Engineers Comments Regarding Surface Water Drainage

Application Reference:	Y/15/25/PL	Reviewer Reference:	ADC/PC
Planning Officer:	Amber Willard	Date of Review:	23/06/2025
Site Name:	Stakers Farm North End Road Yapton BN18 0DU		
Application Description:	Conversion of and alterations to existing barns to create 3 No dwellings, erection of car barn, demolition of existing buildings and associated landscaping and parking and erection of new garage/workshop for Stakers Farmhouse and upgrading of access track. This application affects the character and appearance of the Main Road/Church Road, Yapton Conservation Area and is in CIL Zone 2 and is CIL Liable as new dwellings.		
Assessment Number:	1 of 1

TITLE	
Proposed Drainage Areas Plan	
SCALE	PROJECT No.
1:500 @ A3	23452
REPORT TYPE	DRG. No.
DS	06

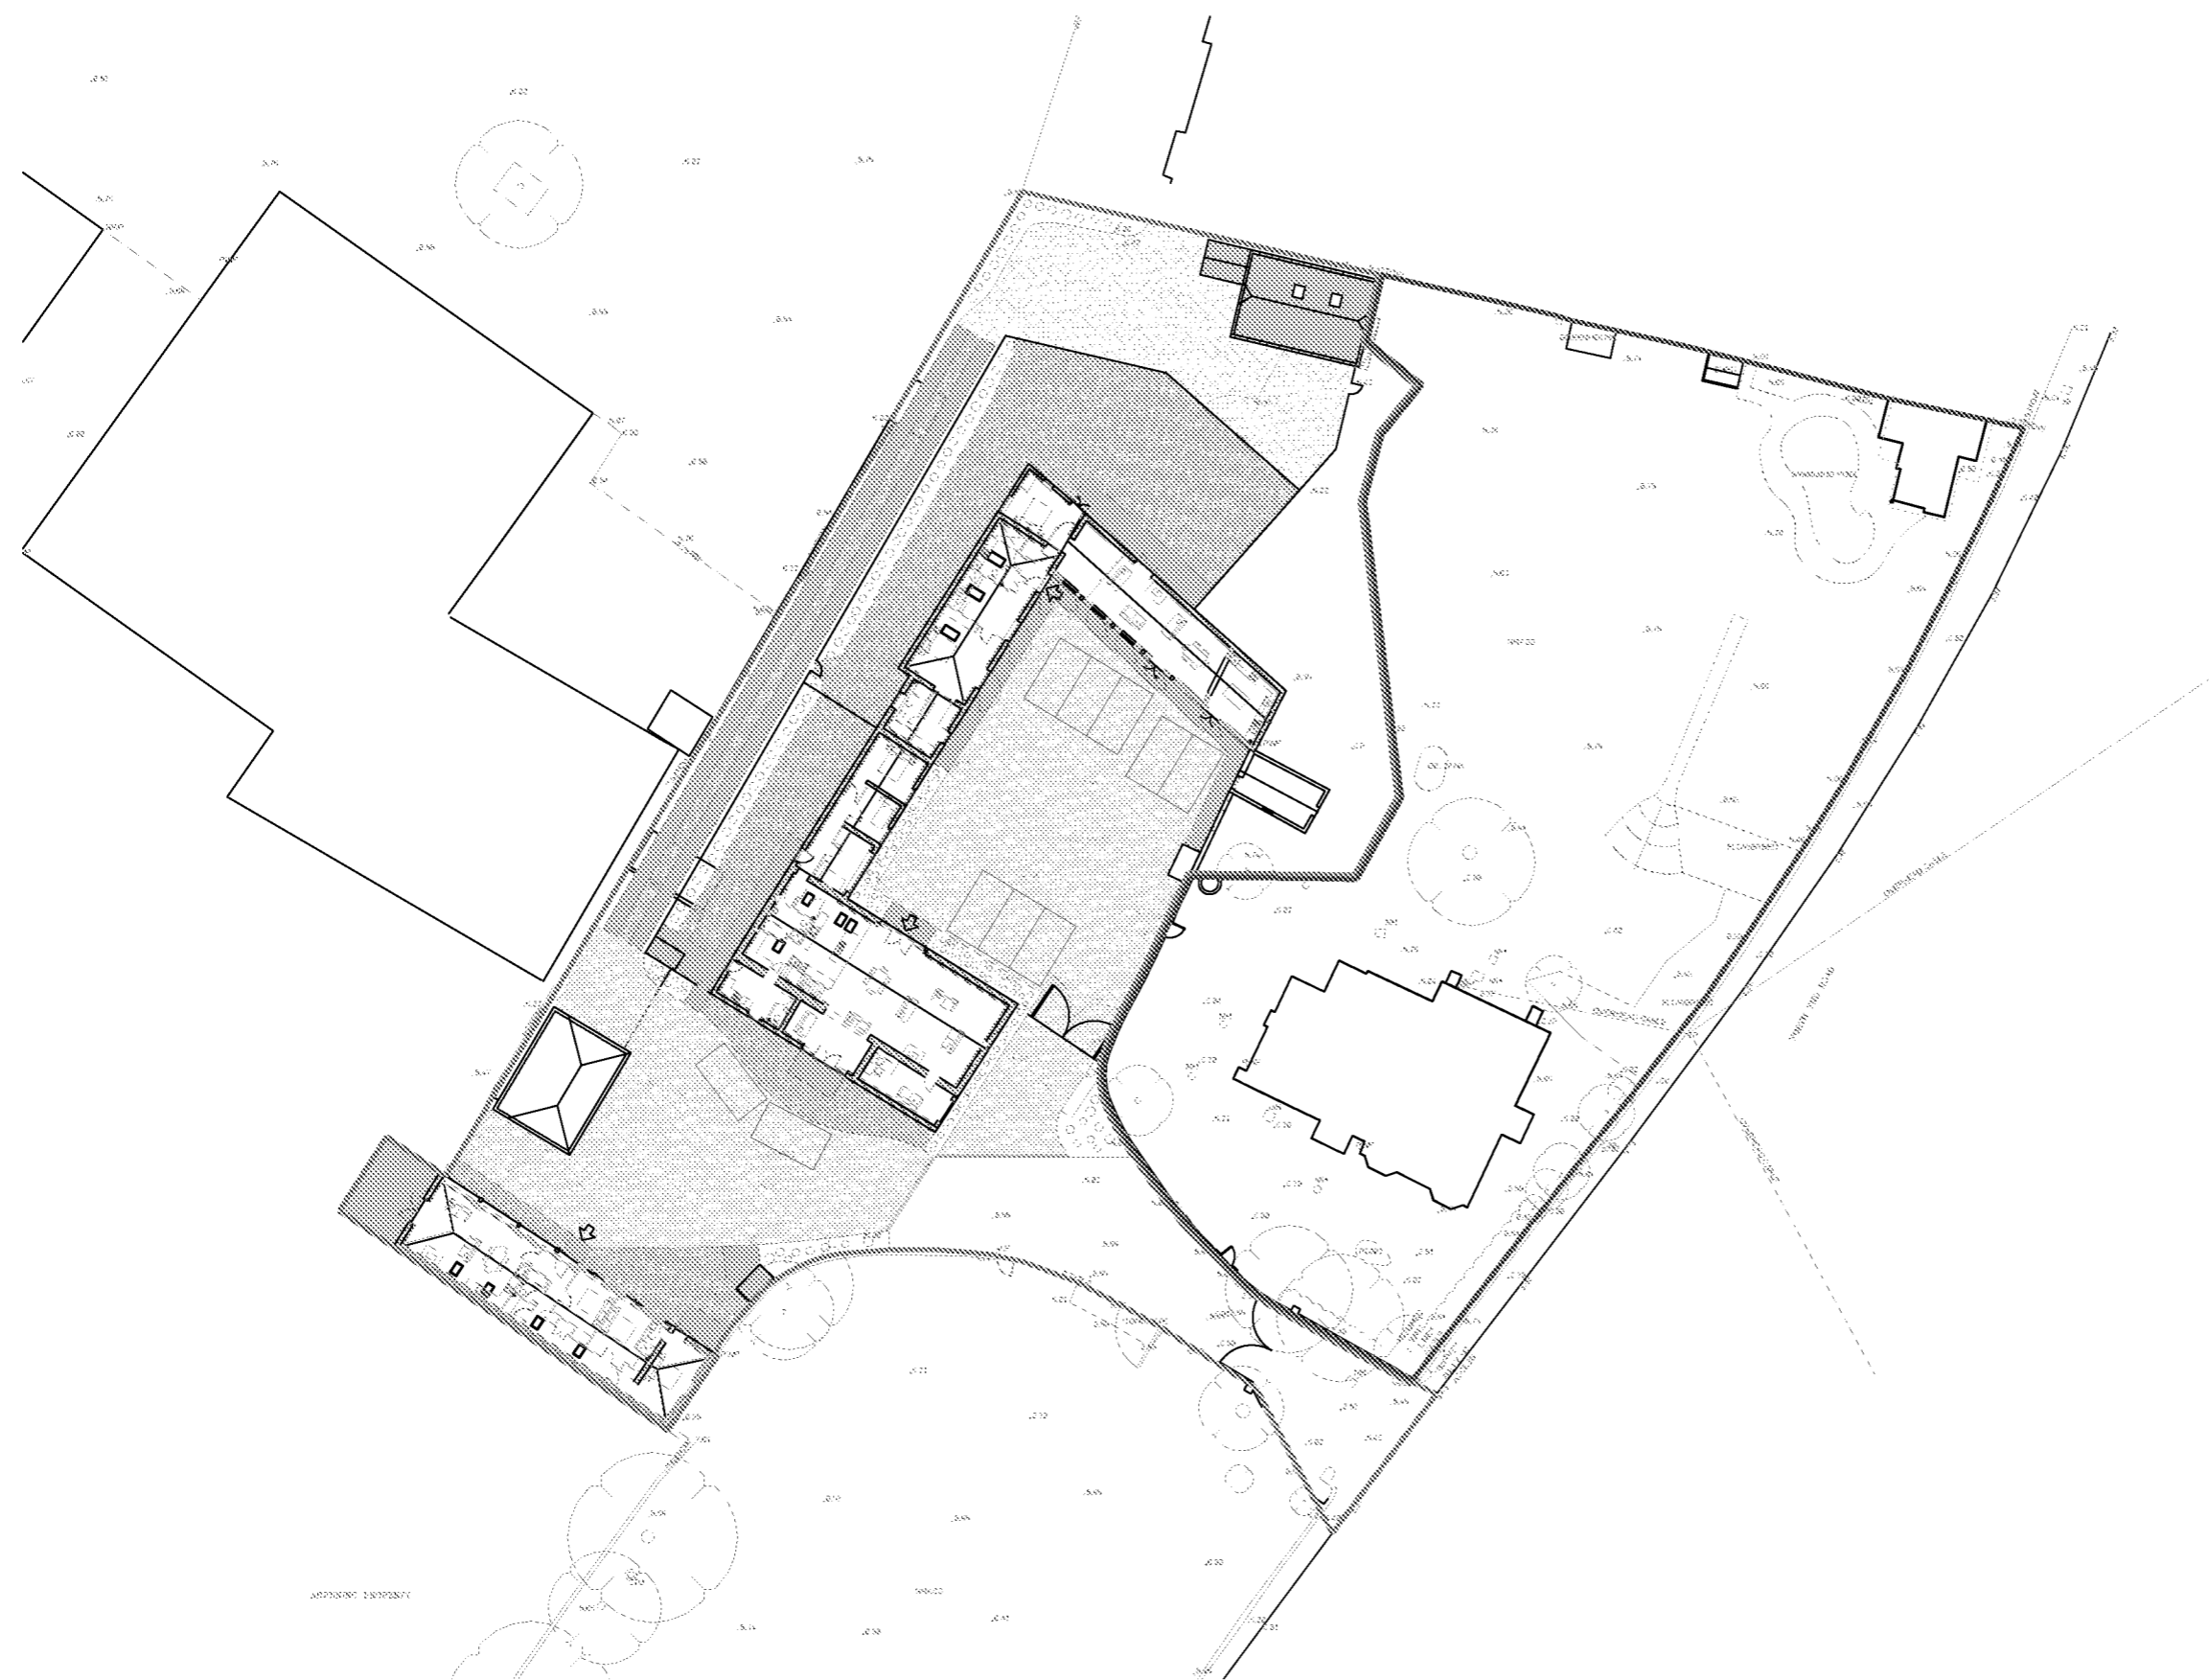
However, the applicants attention is drawn to items 7.1.2 and 7.2.7 of the Civil Engineering Practice Drainage Statement Revision 1.1, in which there appears to be discrepancies between the proposed impermeable/drained areas. This will need clarification and adjustment as necessary.

The design will need to be supported by all the relevant information specified in the applicable checklist discussed below, including hydraulic calculations and supporting impermeable area plans.

MANHOLE 4 WITH HYDROBRAKE  
 (Scale 1:25)

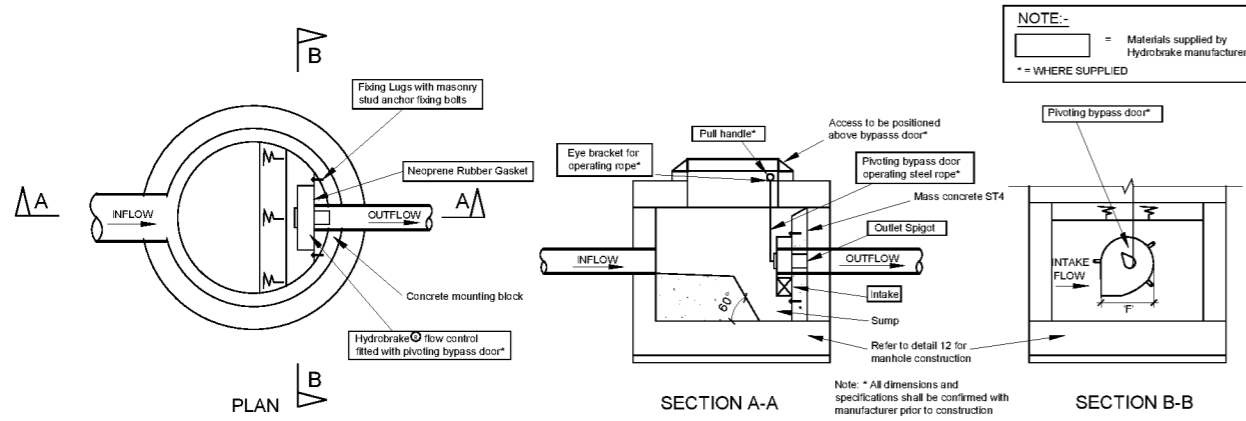
Whilst it is acknowledged that Southern Water have agreed to a 1 l/s surface water discharge to the foul sewer in principle, however, **Surface water must not be discharged into the foul sewer**, irrespective of whether it is considered to be betterment. The foul sewer is not a recognised disposal location in the SuDS Manual, Approved Document H, or the NPPG [**Flood risk and coastal change para 056**]. This is now reinforced by the new 'National Standards for Sustainable Drainage Systems' [National standards for sustainable drainage systems - GOV.UK](https://www.gov.uk/government/uploads/system/uploads/attachment_data/file/612222/national_standards_for_sustainable_drainage_systems.pdf). It is important to recognise that the foul and combined sewer networks are defined by the public sewer records held by Southern Water Services Ltd.

If the applicant can retain permission from Southern Water to make the proposed connection - despite this going against their policy - then we will continue to oppose the proposed connection based on it not being allowed for within the PPG, The SuDS Manual or Approved Document H.
